Outdoor seating area on pavement consisting of 2 No. tables & 4 No. chairs to be stored when not in use.

Andalucia Restaurant 58 Ferring Street Ferring

Thank you for your internet representation made on 8th October 2018 which has been recorded as '**an objection**' with the comments as follows:

PROJECT	RESTAURANTE ANDALUCIA 58-60 Ferring Street, Ferring BNT2 5JP		
TITLE			
PROPOSED CHANGE OF USE AND TABLES AND CHAIRS LICENSE			
DRAWN	DATE	SCALE	CHECKED
RM	August 2018	shown	
PROJECT	NUMBER		REVISION
BD 18114	09-01		-

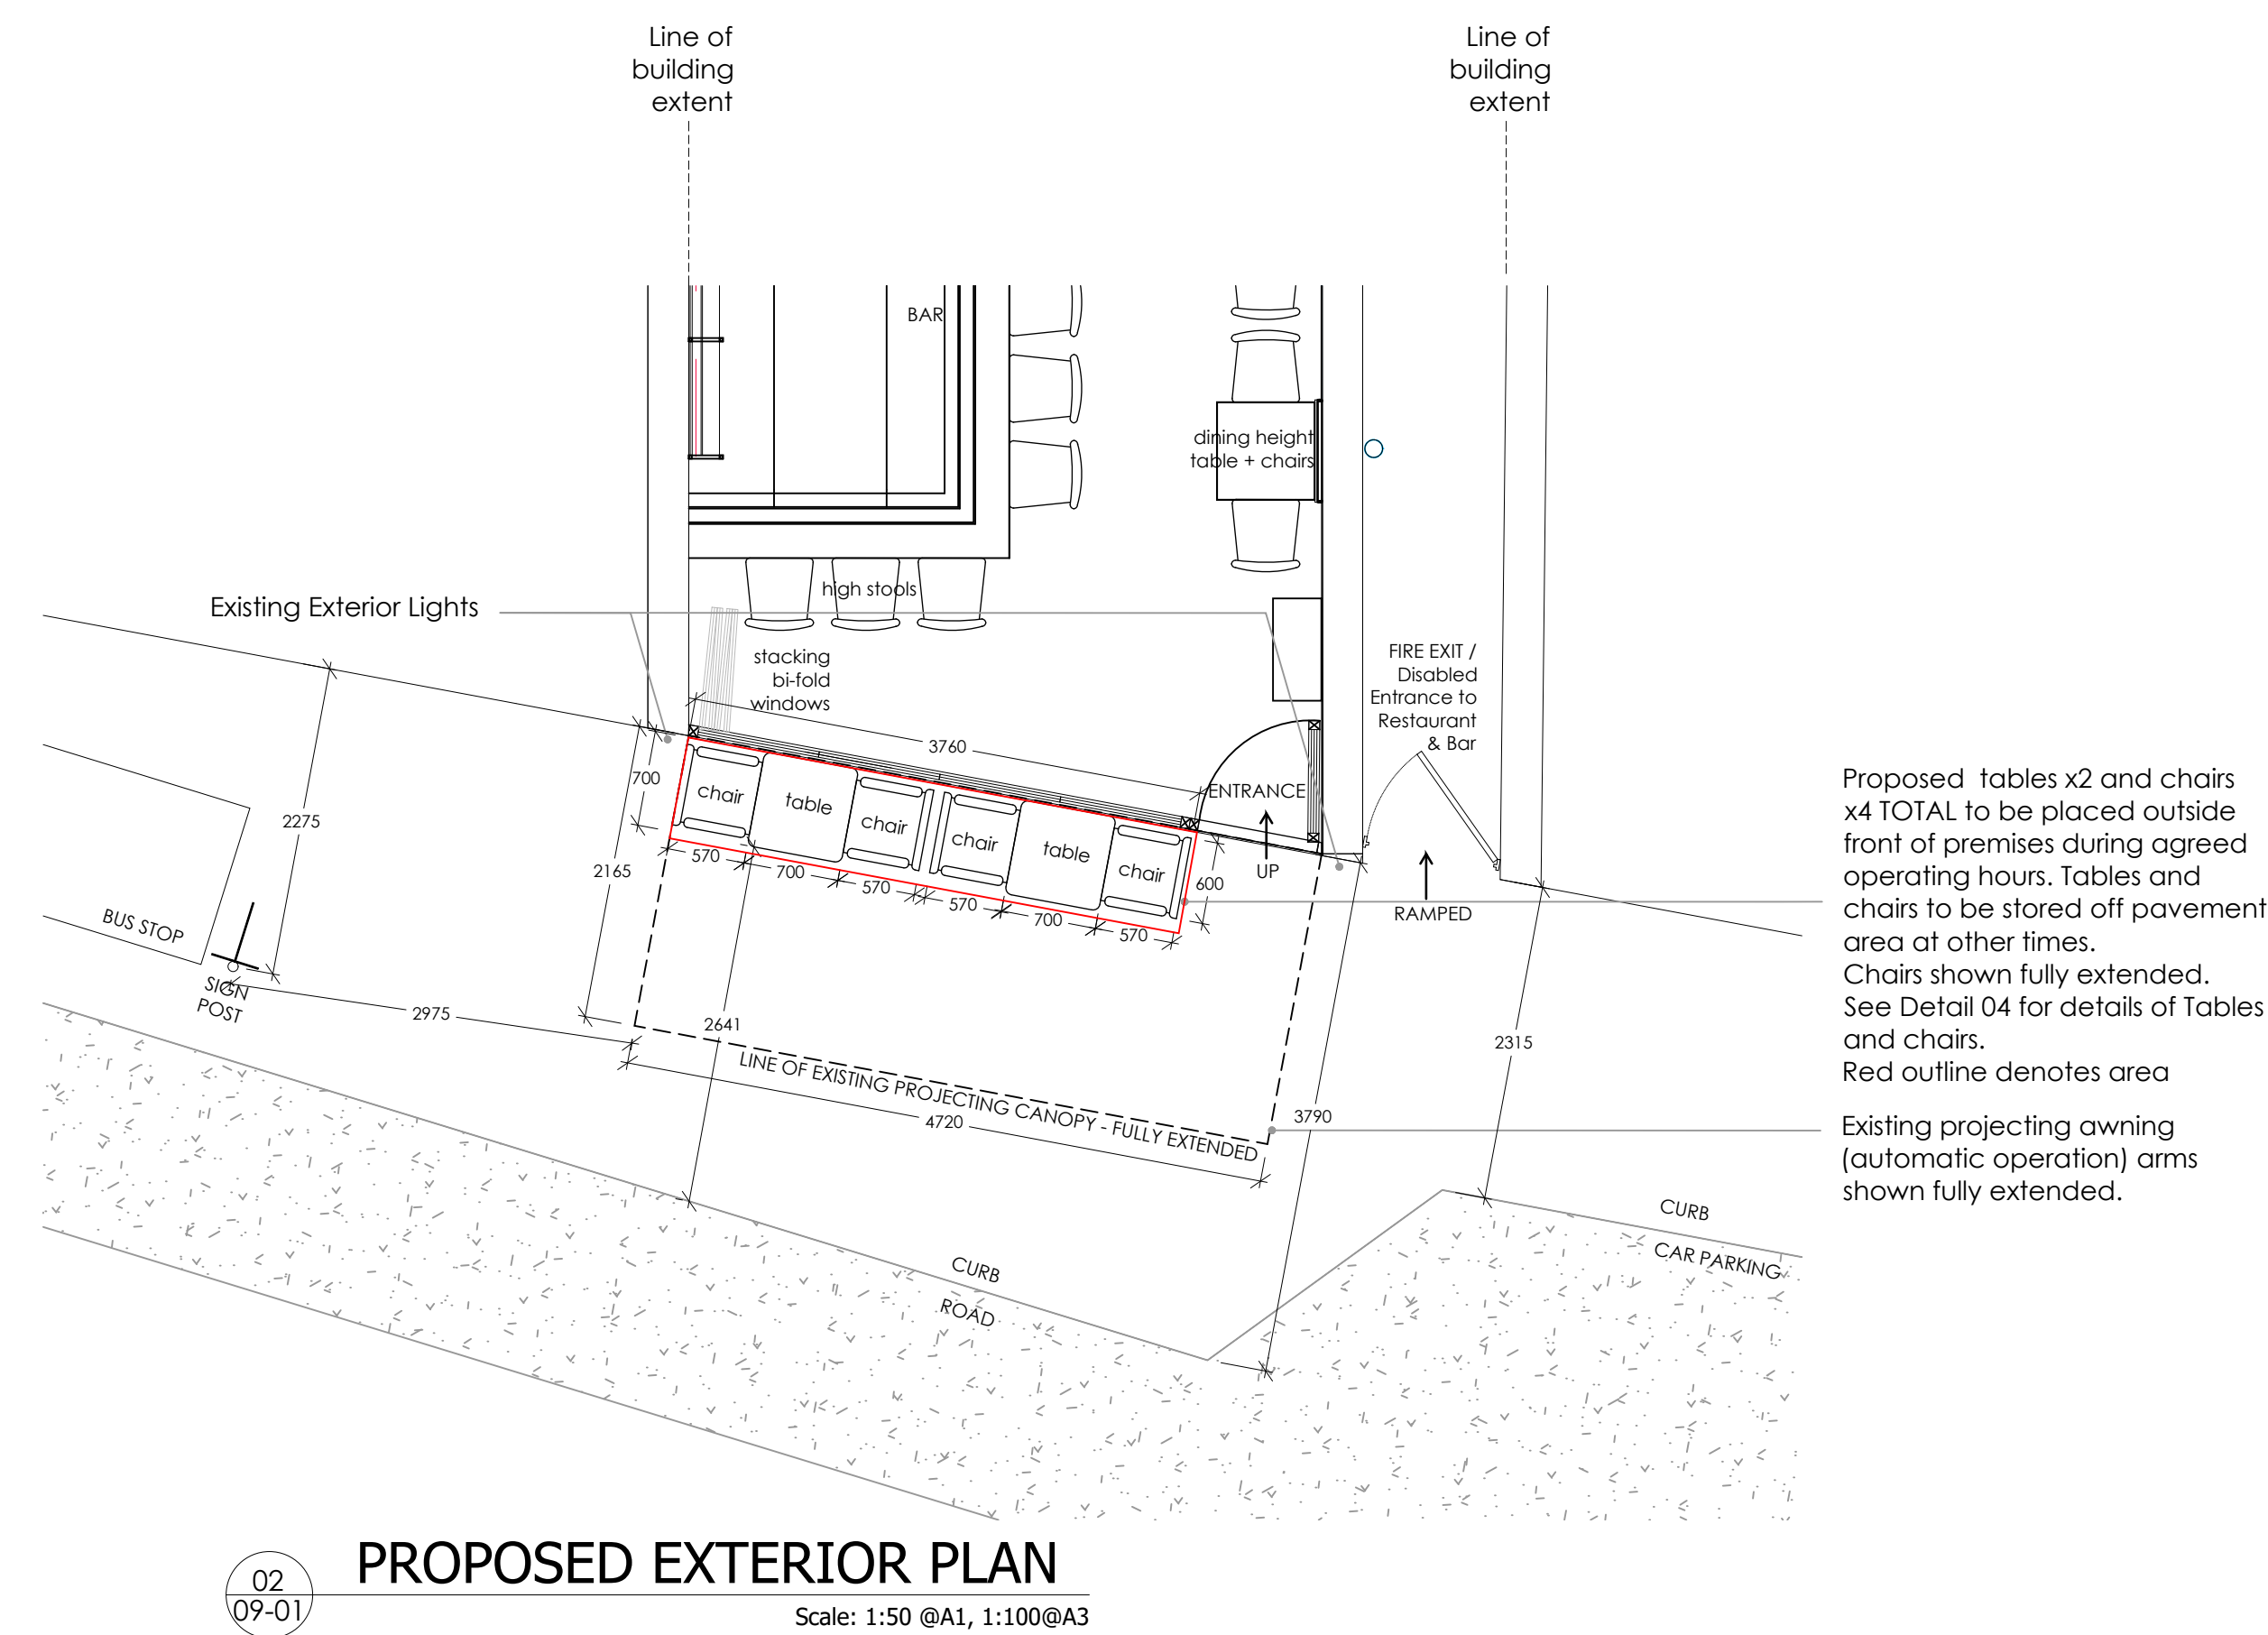
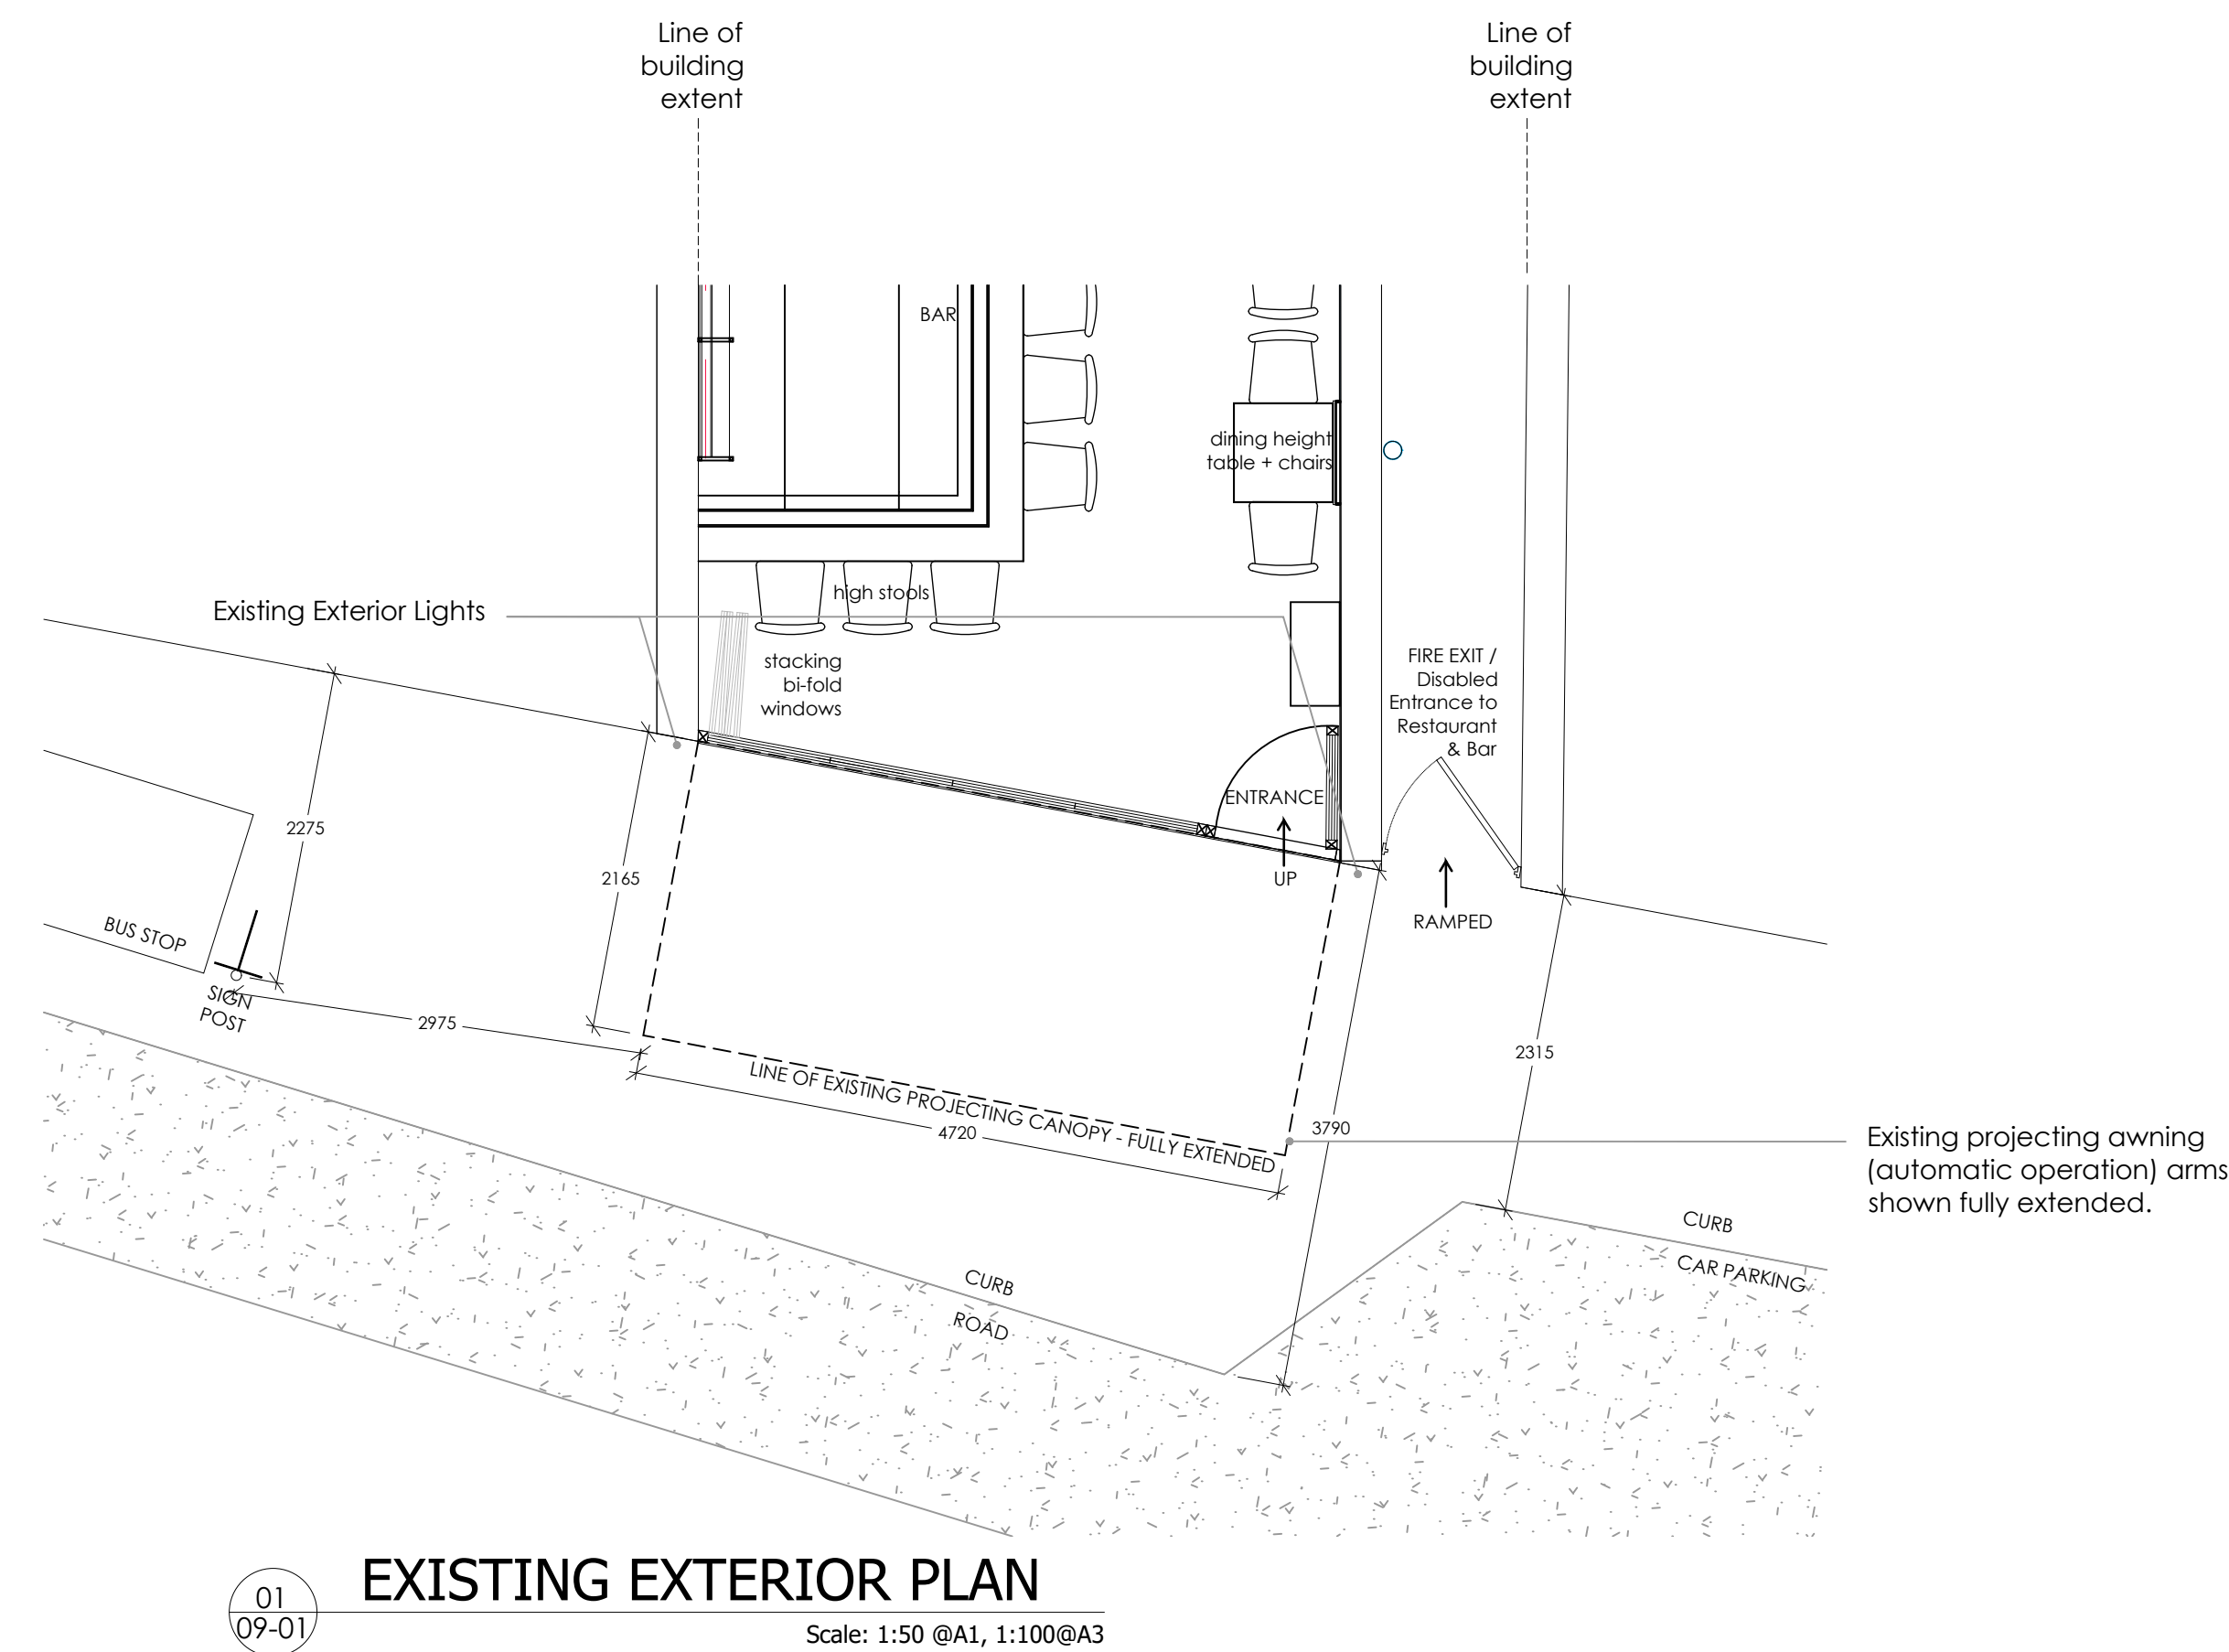
Whilst I welcome outdoor coffee culture in the village I believe there is a definite lack of space at the frontage of Andalucia for chairs etc. This would create a great problem to passers by & bus passengers at the nearby bus stop as they would be forced to have to walk on the roadside.
